Arun District Council
Arun Civic Centre
Maltravers Road
Littlehampton
West Sussex BN17 5LF
Planning & Building Control General Enquiries
Tel: (01903) 737756 Fax: (01903) 730442
Dx: 57406 Littlehampton
Minicom: 01903 732765
e-mail: planning@arun.gov.uk
website: www.arun.gov.uk/planning

Application No: AB/38/22/HH
Site Address: 114 Fitzalan Road Arundel BN18 9JY
Description of works: Retrospective application for the construction of a summerhouse to the rear of the dwelling.

Thank you for your internet representation made on 16th May 2022 which has been recorded as an objection with the comments as follows:

Title:
Proposed Elevations

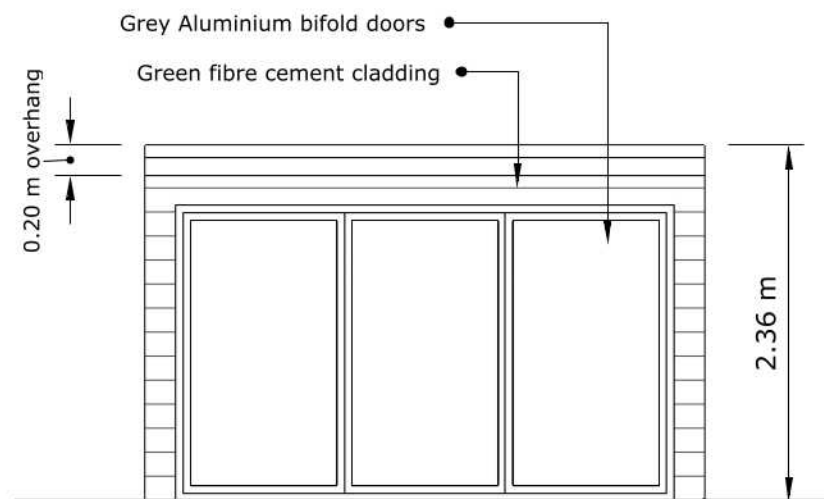
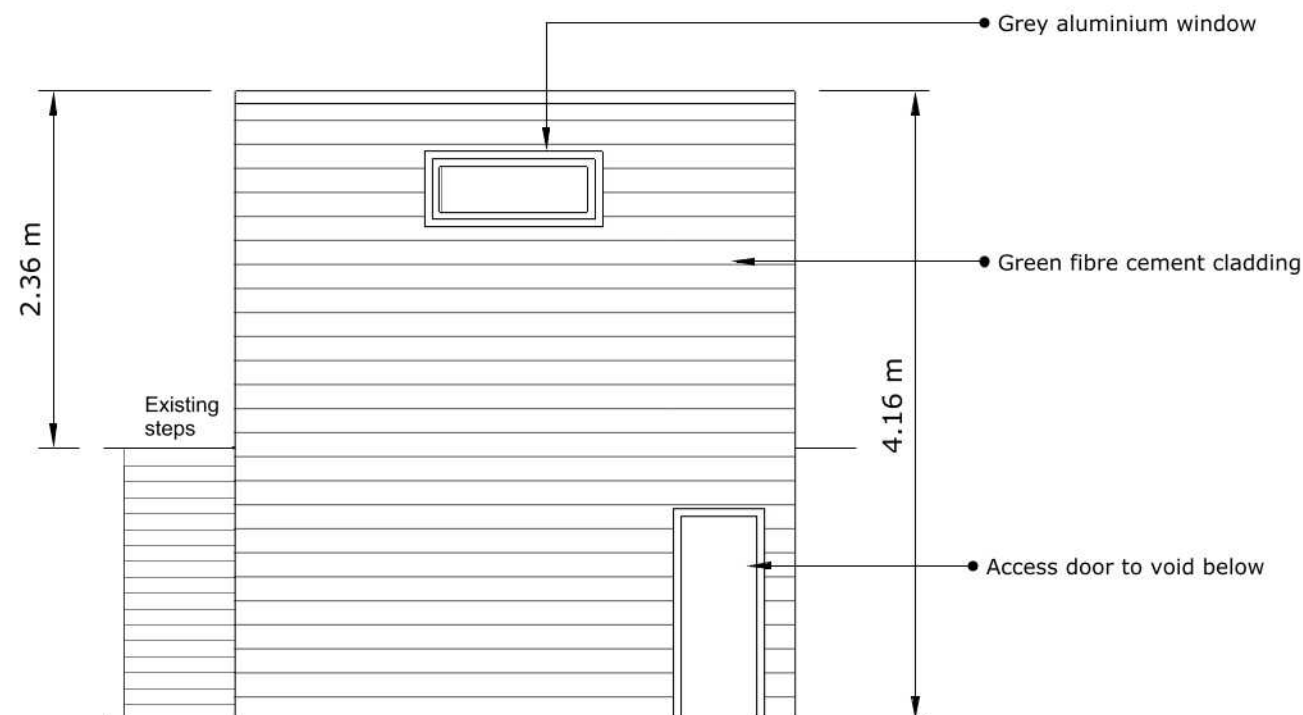
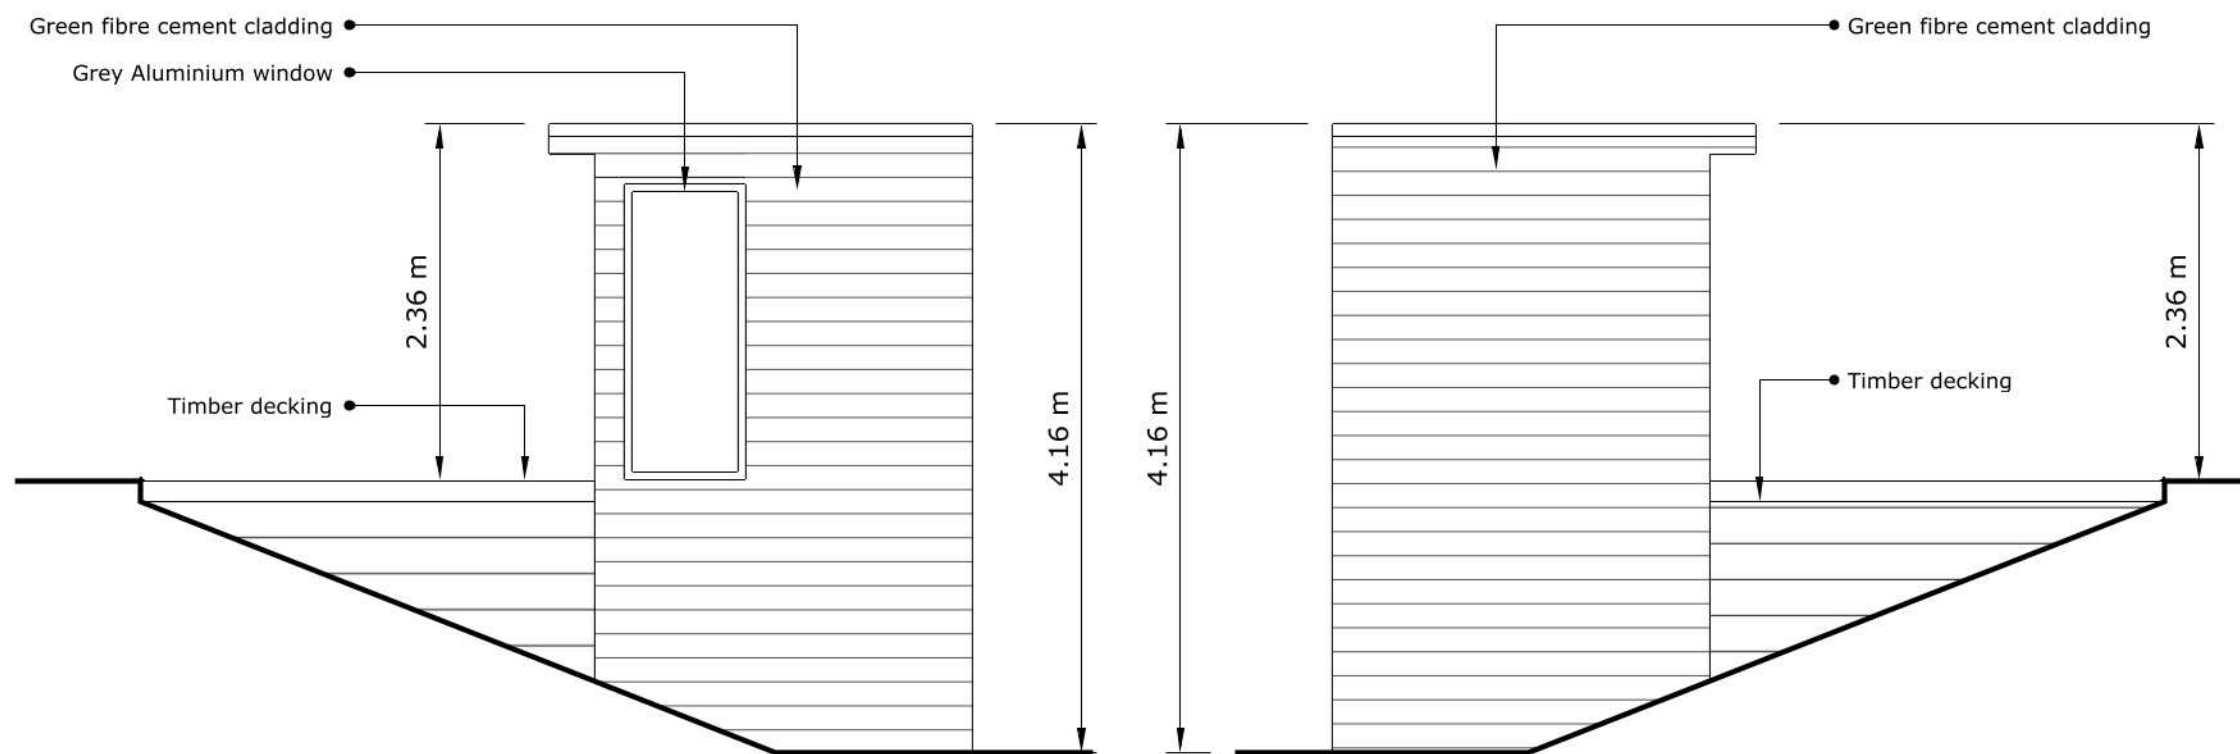
The summerhouse of 114 is built too close to the adjoining property.
The decking is also higher on the bank than the others thus blocking the flow of the river line and bank. The height is also not in sympathy with its neighbours. Particularly 112.
